Sent: 11 November 2010 16:22
To: Planning
Cc: Heywood Karen, Bewick Stewart, Martin Edward, Anita Ward
Subject: Application N6/2010/2055/MA Shredded Wheat Factory, Welwyn GC

Please find below Network Rail's response to the application for development of the former Shredded Wheat factory at Welwyn Garden City (N6/2010/2055/MA).

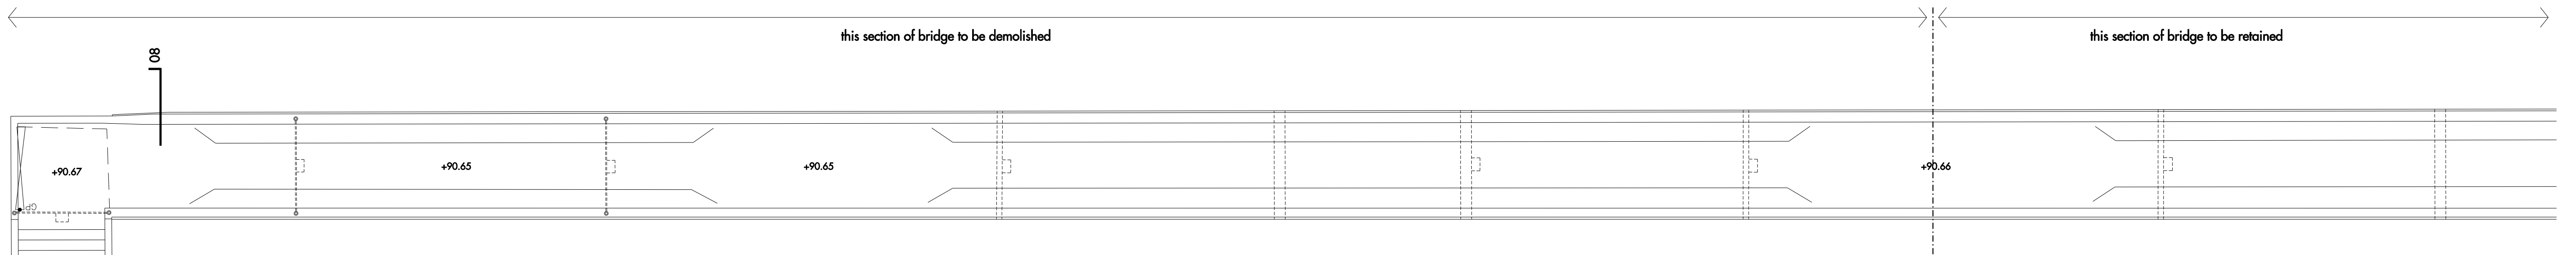
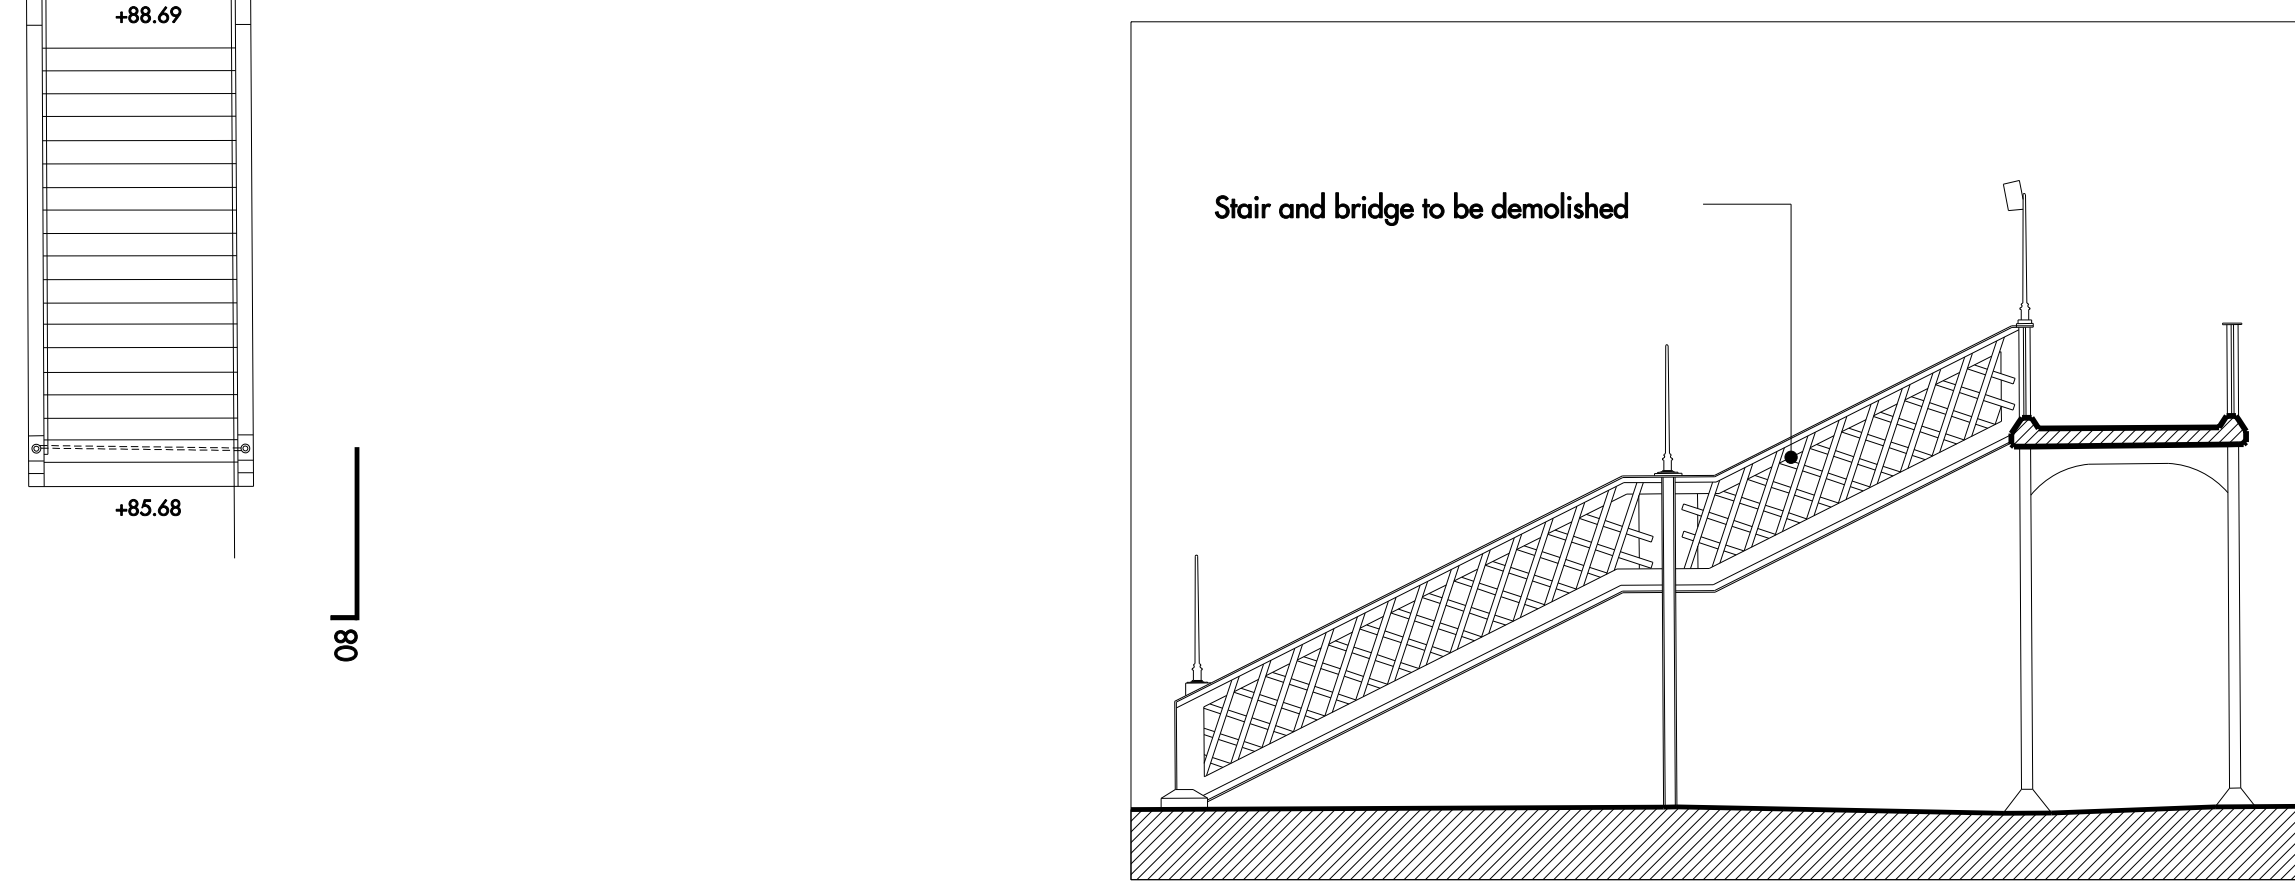
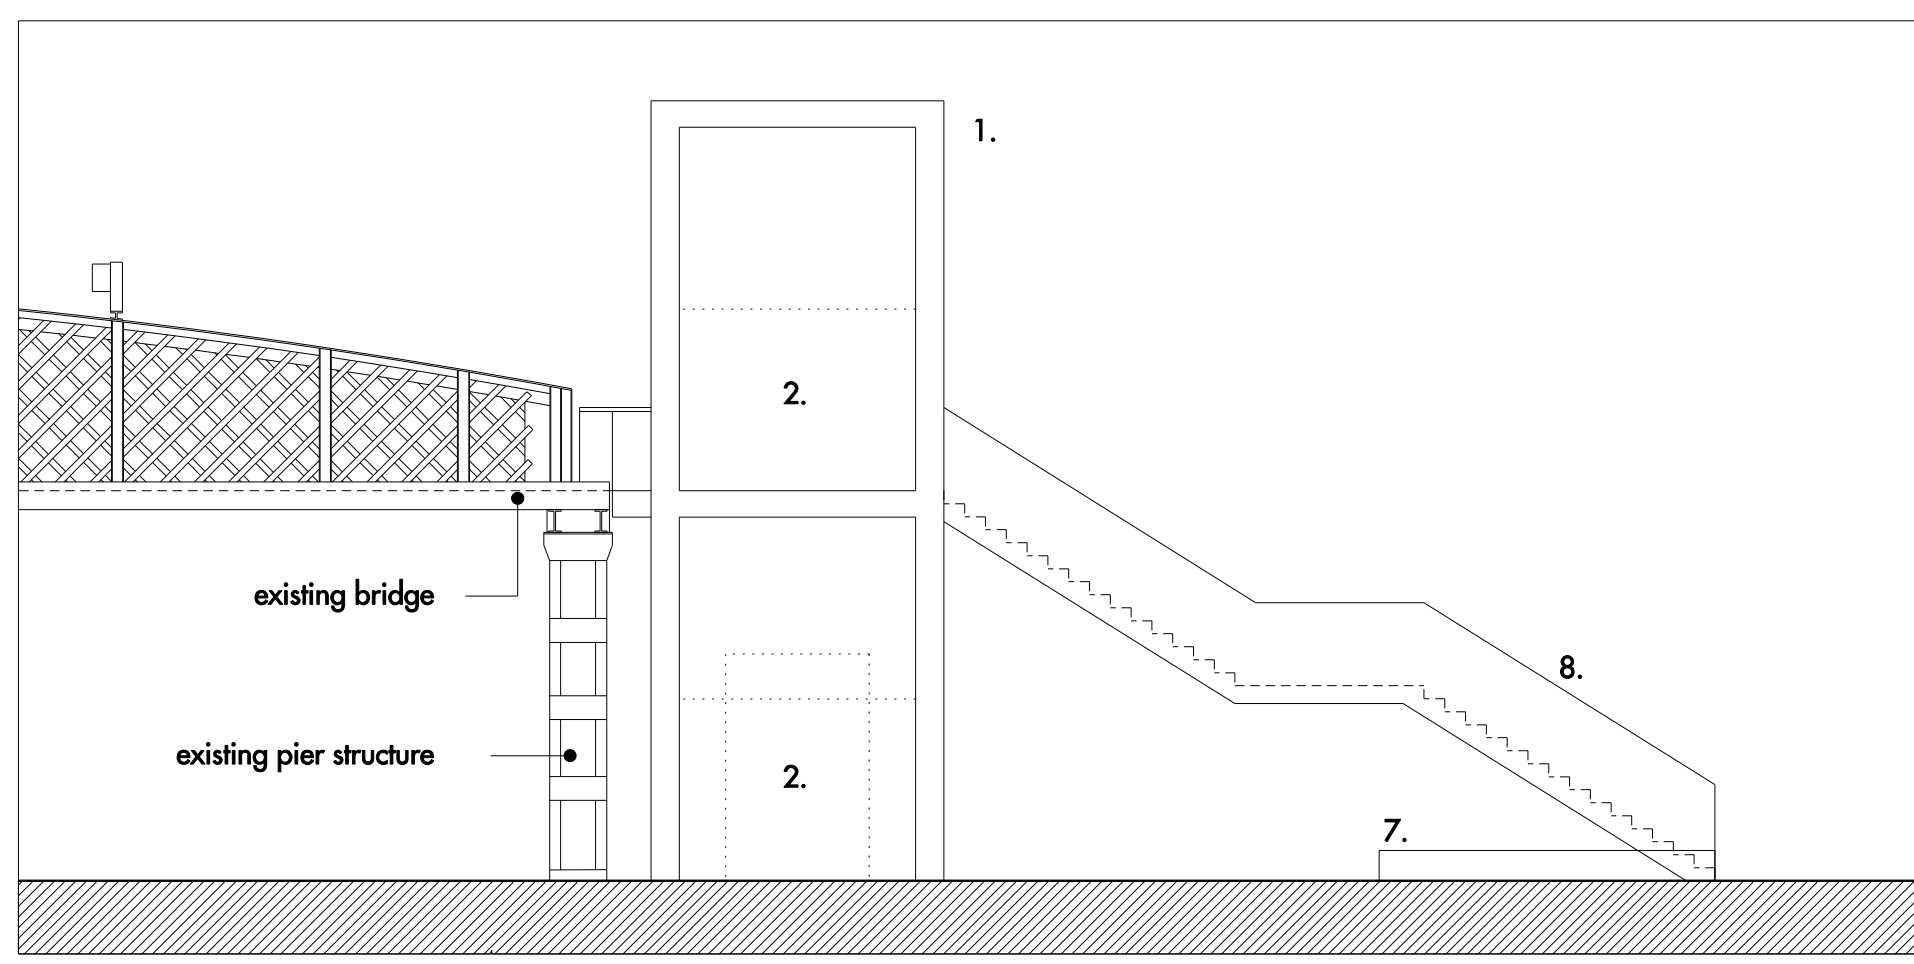
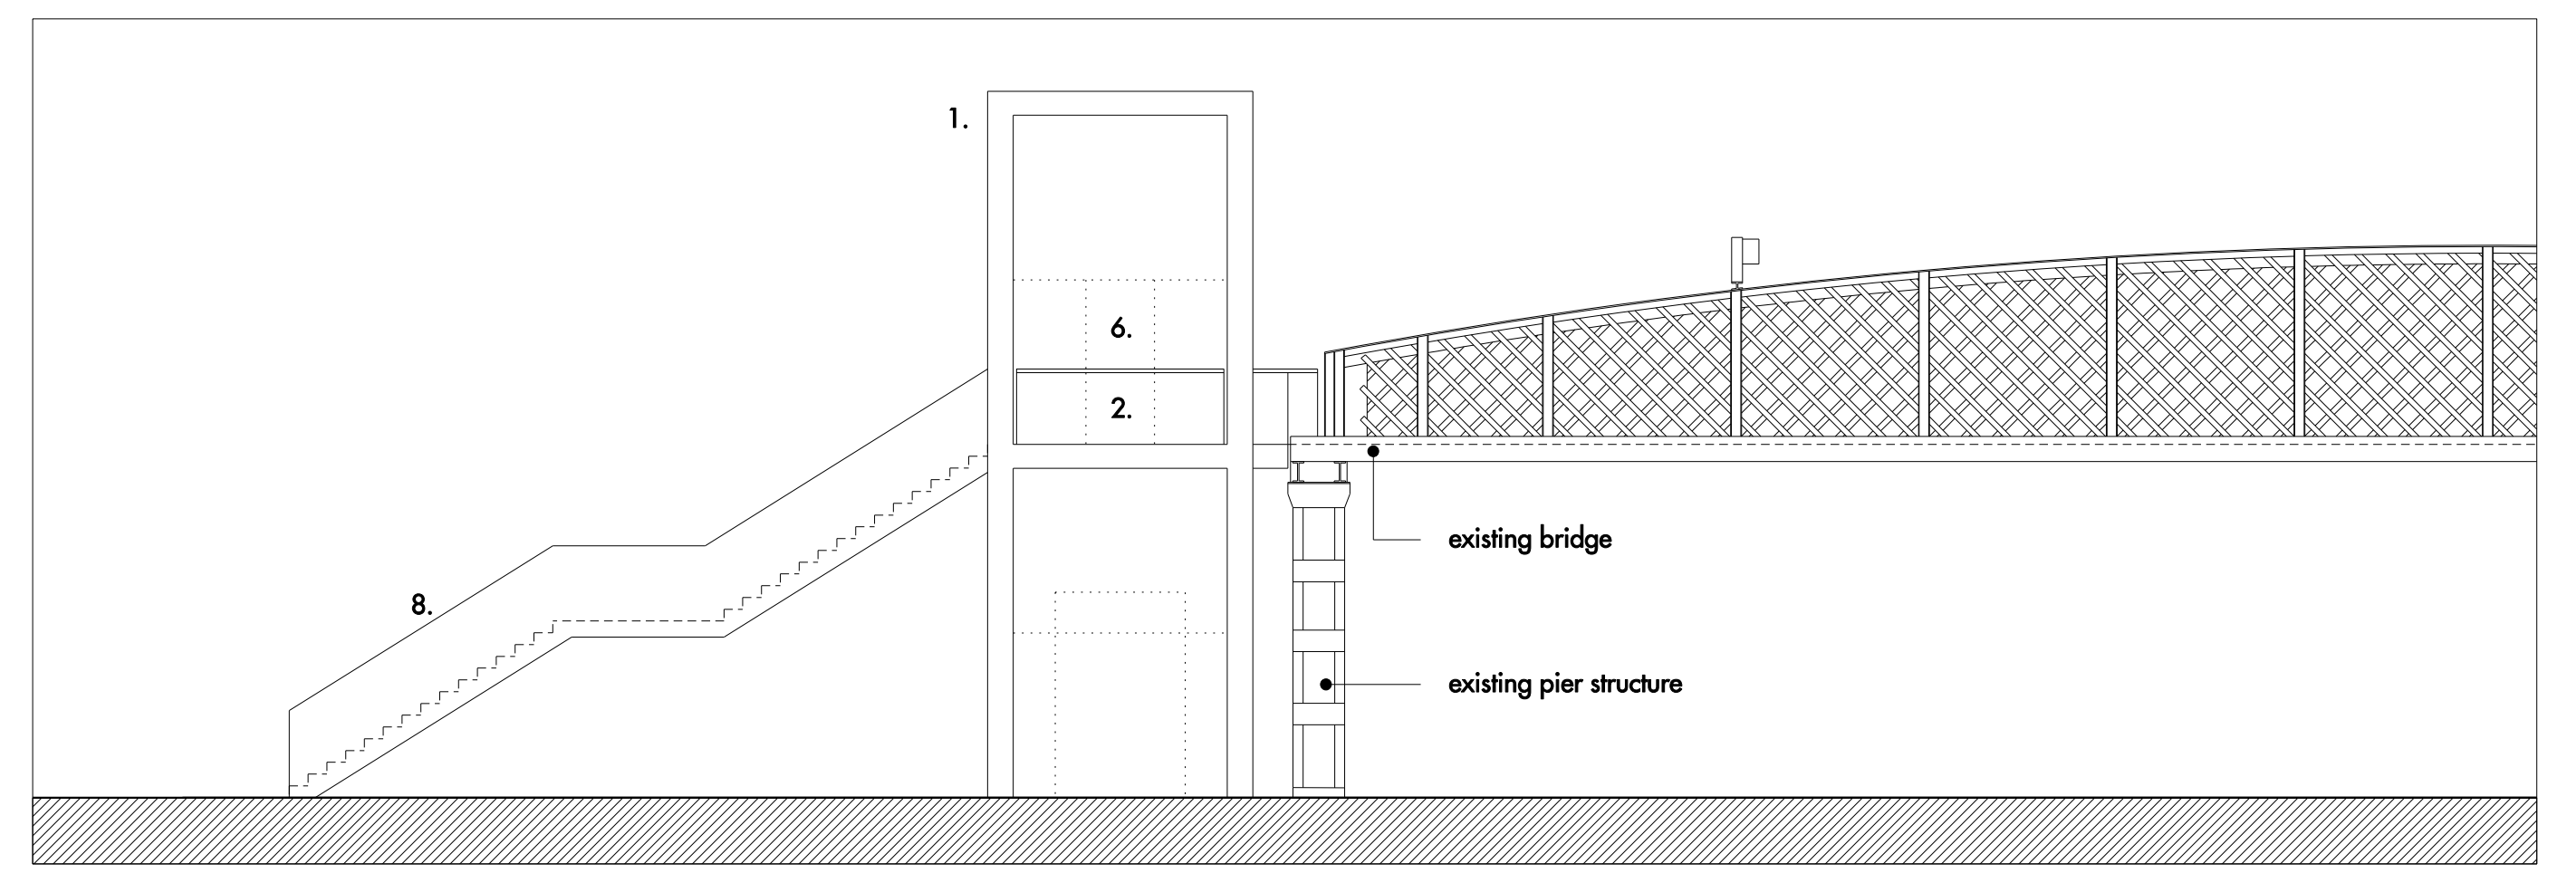
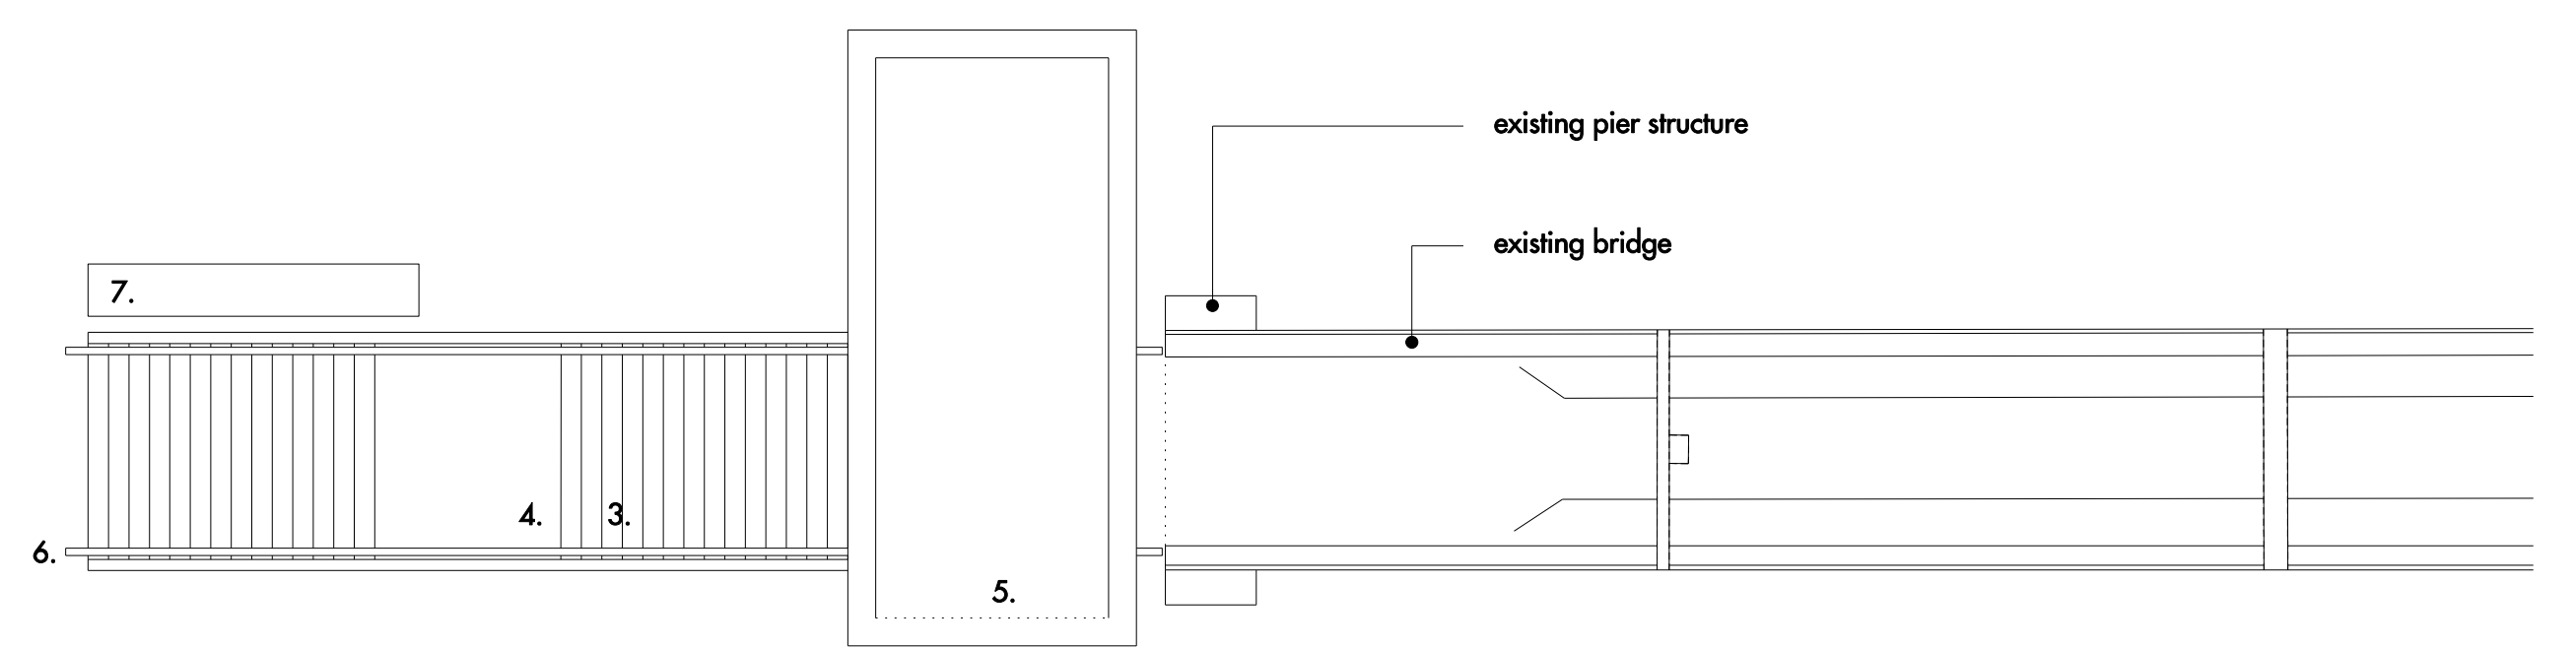
The proposal as tabled provides for the removal of the redundant spans at the east end of the structure and the provision of a new staircase and lift to gain access to the bridge, station and Howard Centre beyond. However there is no consideration of the increased use of the footbridge as a result of the overall development; there are no figures (as far as can be ascertained) on what the increased footfall over the bridge would be overall. Mention is made of perhaps an additional 200 or so rail trips associated with the development but there is no estimate of how many people would use the bridge to gain access to the town centre, or how many would go in the opposite direction on foot to the various uses proposed (particularly the supermarket and leisure centre). Our immediate concern is whether the existing bridge structure could cope with the increased footfall resulting from the development. This work should emerge as part of the feasibility study currently being carried out. We hope to have some initial feedback on this w/c 22nd November, so we will have to reserve judgement on this particular aspect until that week at the very least.

Clearly we are supportive of the proposal to shorten the existing bridge spans but the option tabled represents the least form of improvement in terms of attractiveness and does not reflect the aspirations of the Authority as expressed in the development brief. We would also be concerned about potential pinch points within the retained structure if there is a significant increase in footfall predicted. Additional issues such as the maintenance of the new structures will also have to be taken into account. As such we would expect the results of the feasibility study discussed above to influence the determination of the application with respect to these aspects of the proposal.
